Conservation Area Advisory Committee

ADDENDUM
SHEET

AB/36/18/PL: SHELTERED HOUSING, FITZALAN RD, ARUNDEL

Reveal Elevation (South West)
Fronting Fitzalan Road

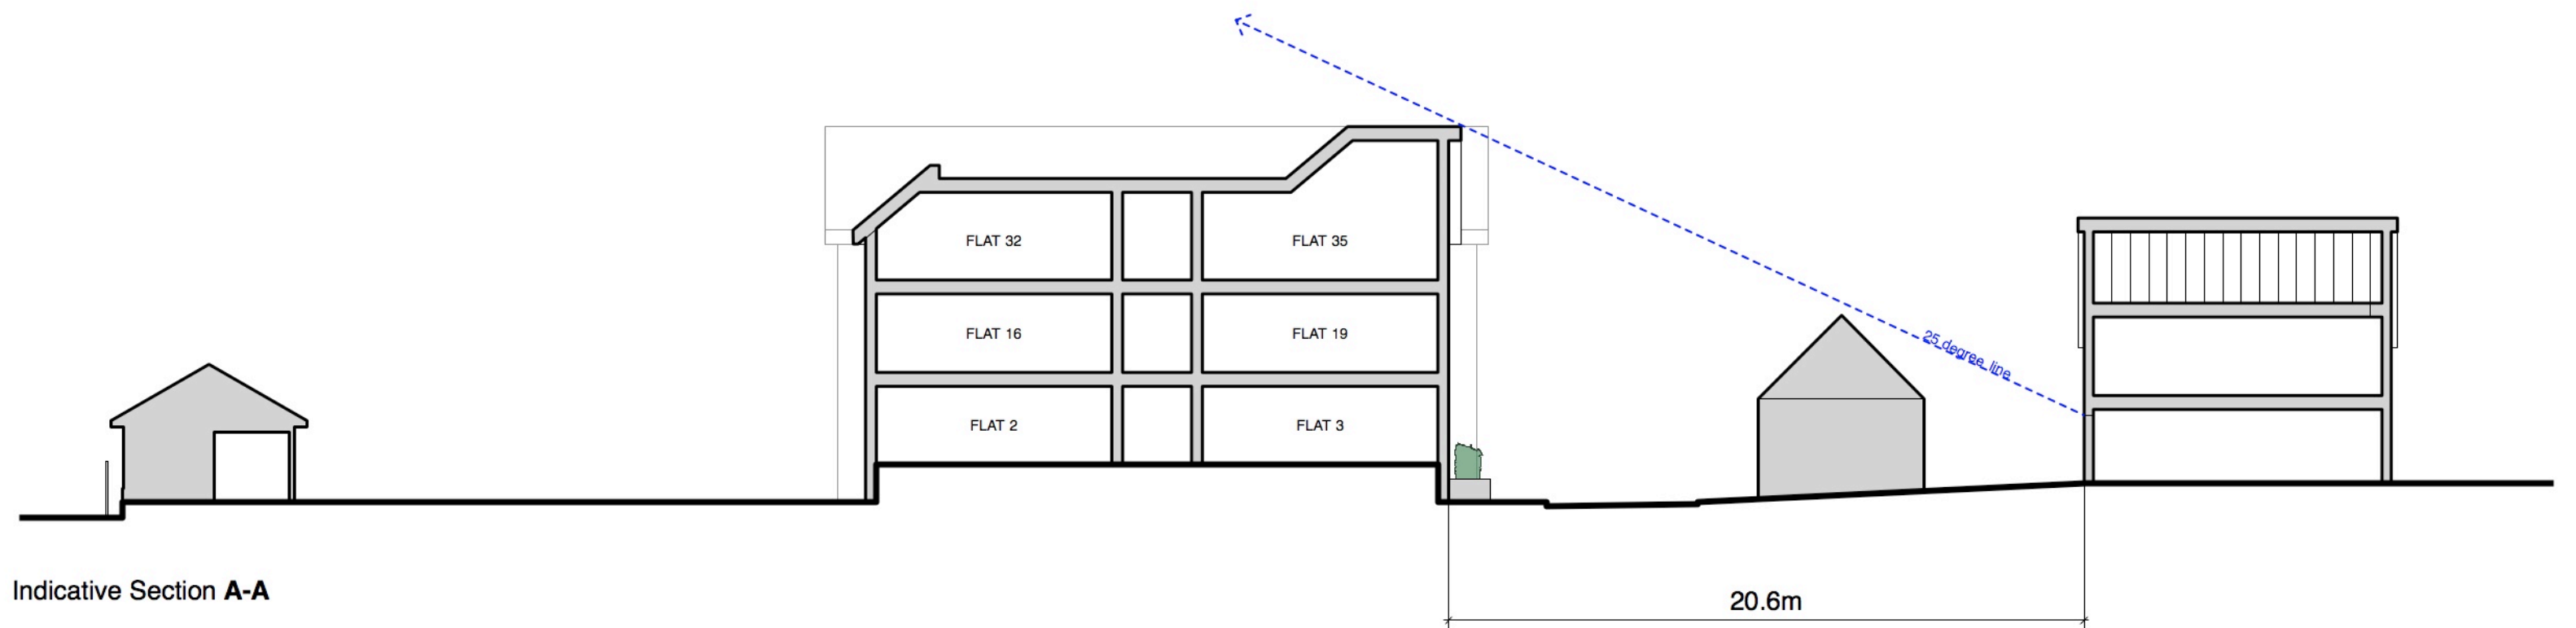
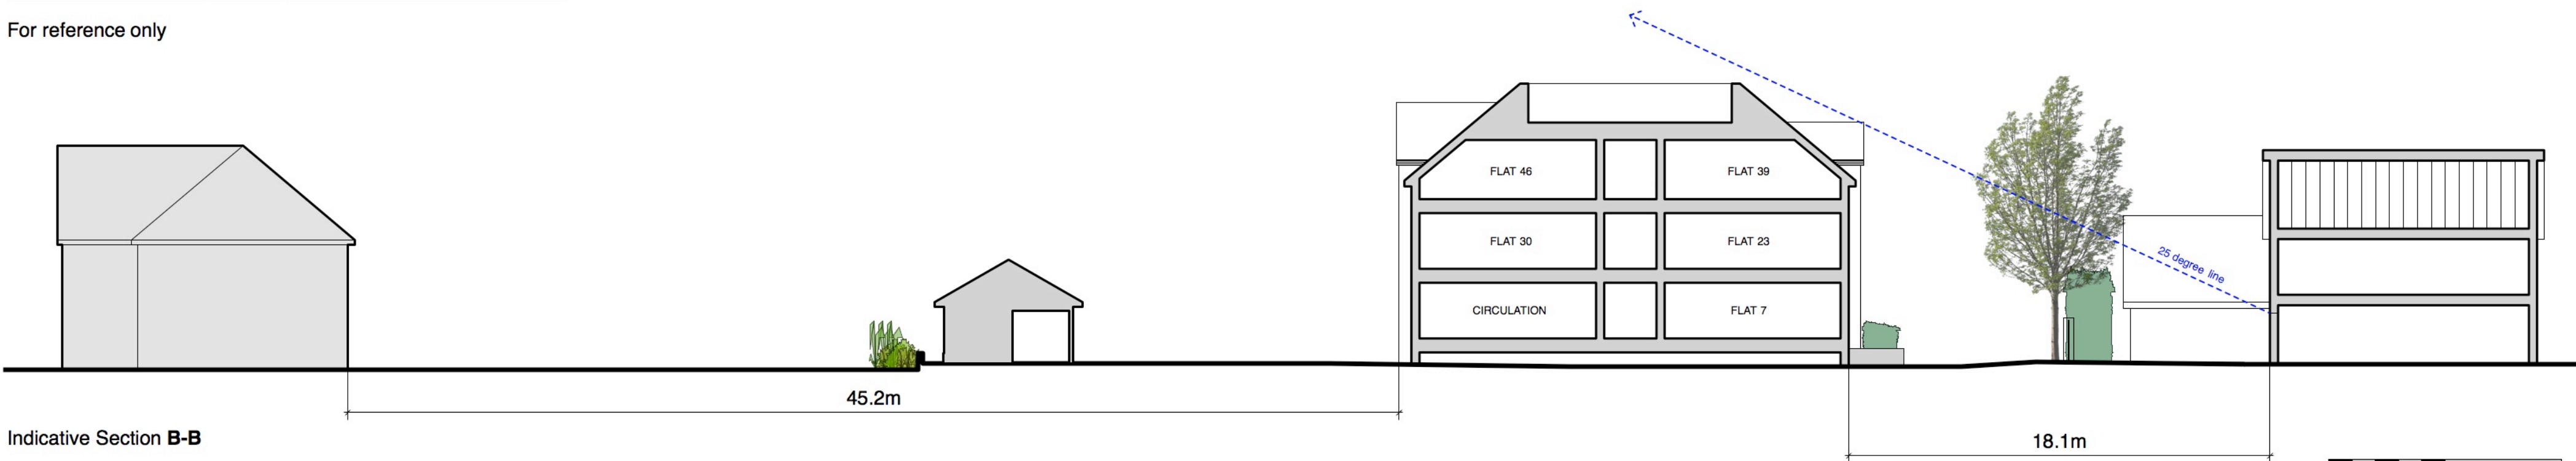
1. Over development of site
2. lacks adequate design quality
3. Far too bulky, much more sensitive approach to form and massing is required
4. Existing brewery buildings should be retained as heritage assets
5. Scheme compromises suburban character of the south-west leg of Fitzalan Rd
6. Scheme adversely affects the setting of and the approach to the Conservation area
